Word & Glory Church

Fire Marshal Division

Re: Word and Glory Church
109 E. B Street
Erwin, NC 28339

Application Number BCOM2506-0003

Life Safety Plan

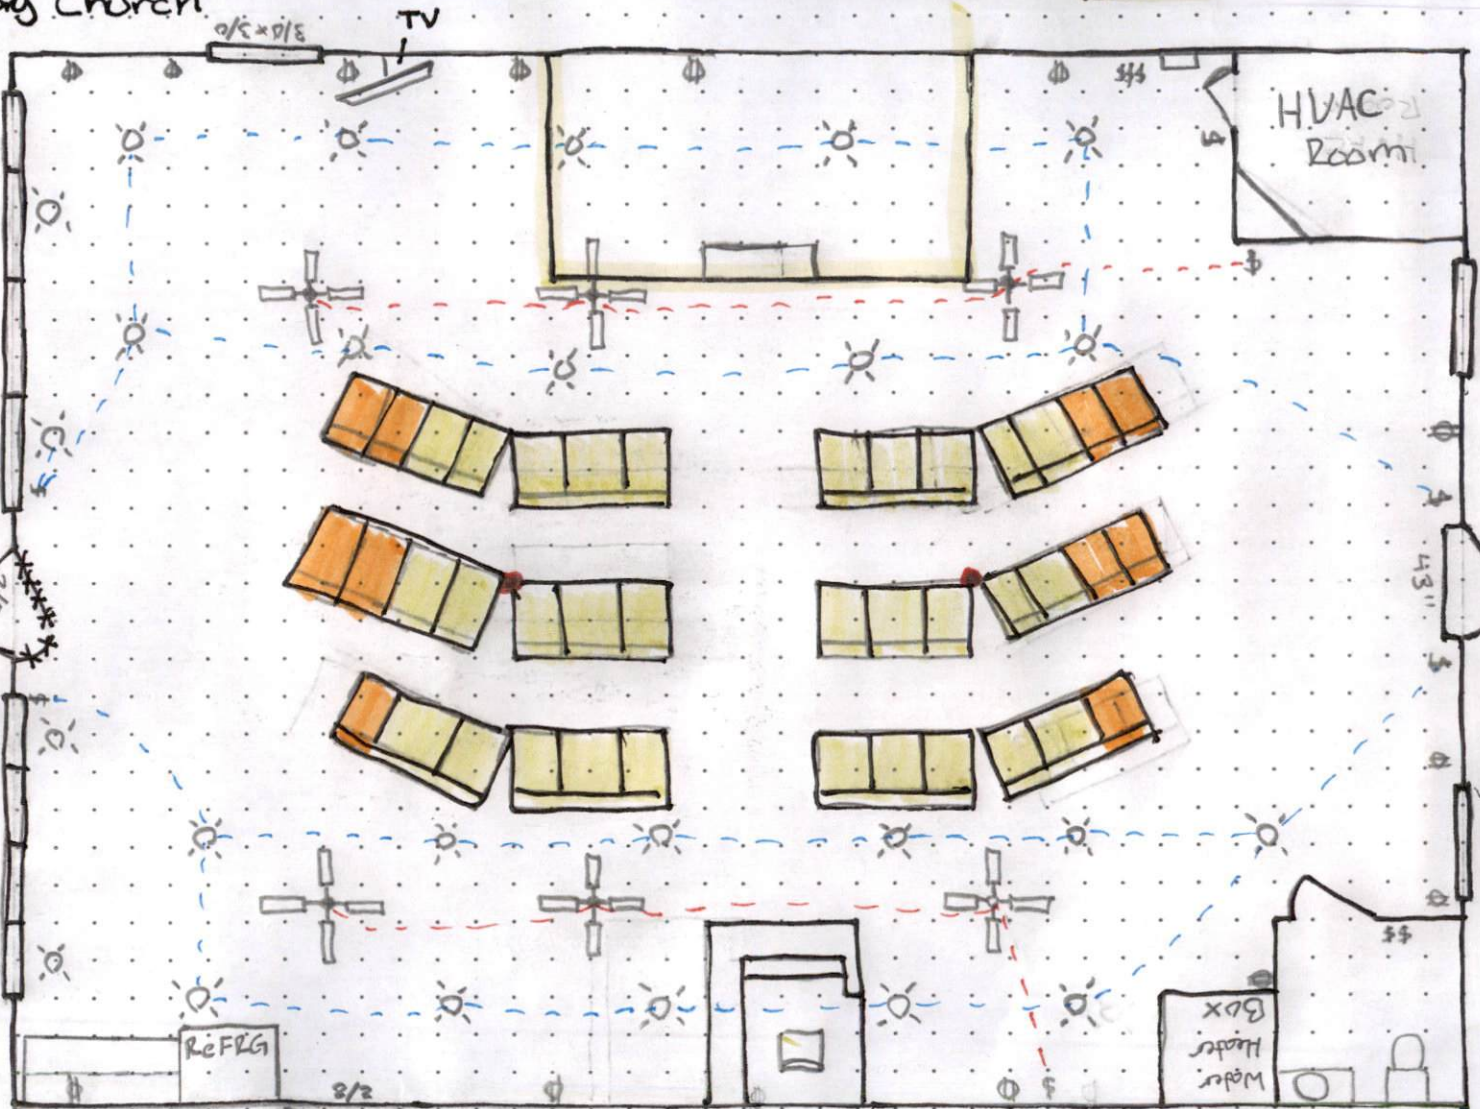
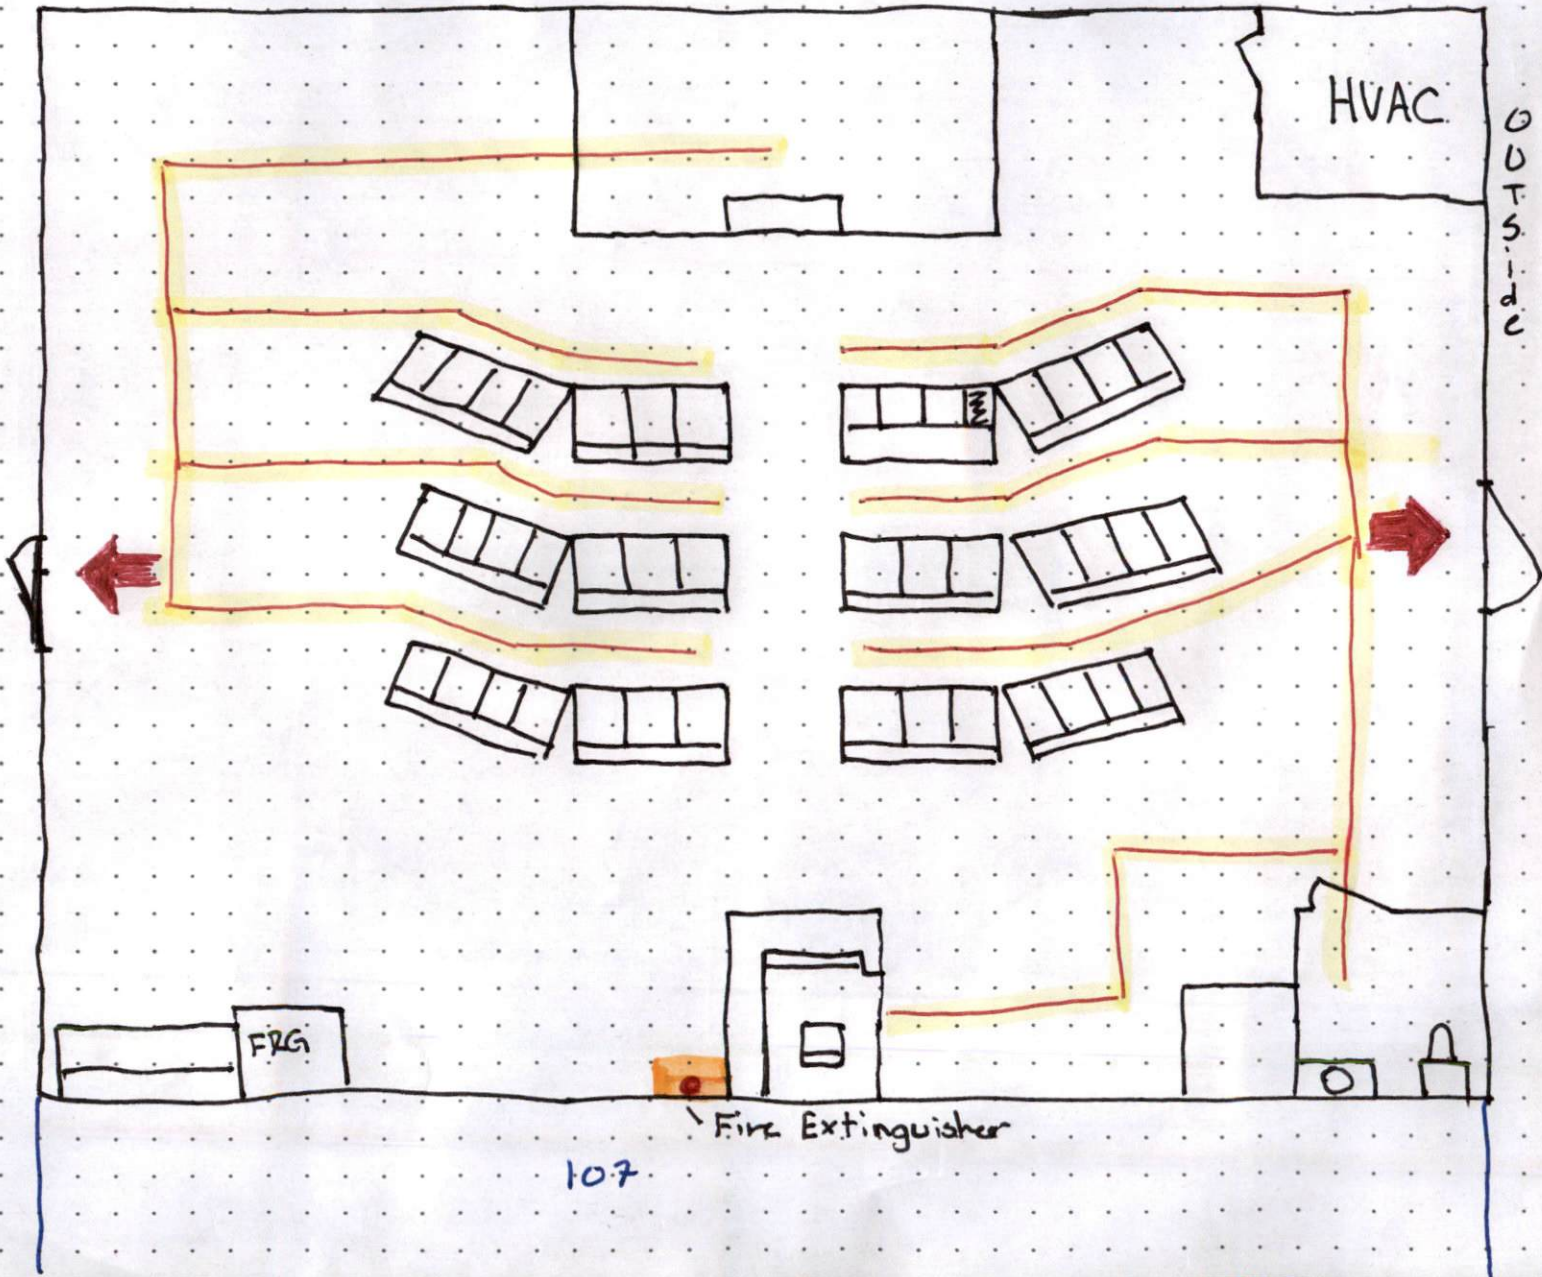
- The fire extinguishers provided shall have a minimum rating of 2A10BC and shall not be mounted higher than 5 feet above the finished floor level.
- All fire extinguishers shall be properly mounted and tagged by a fire extinguisher company.
- Travel distance to a fire extinguisher shall not exceed 75 feet.

- **Panic Hardware**
 - UL 305 listed panic hardware is required on exit doors serving a room/space with an occupant load >50.
 - Both the front and rear doors will be required panic hardware and must swing in the direction of travel.

- **Means of Egress Illumination**
 - The means of egress illumination shall not be less than 1 foot-candle at the walking surface.
 - The means of egress, including the exit discharge shall be illuminated all times when the building is occupied.
 - Exit/Emergency light exit signs need to be installed at front and rear doors.
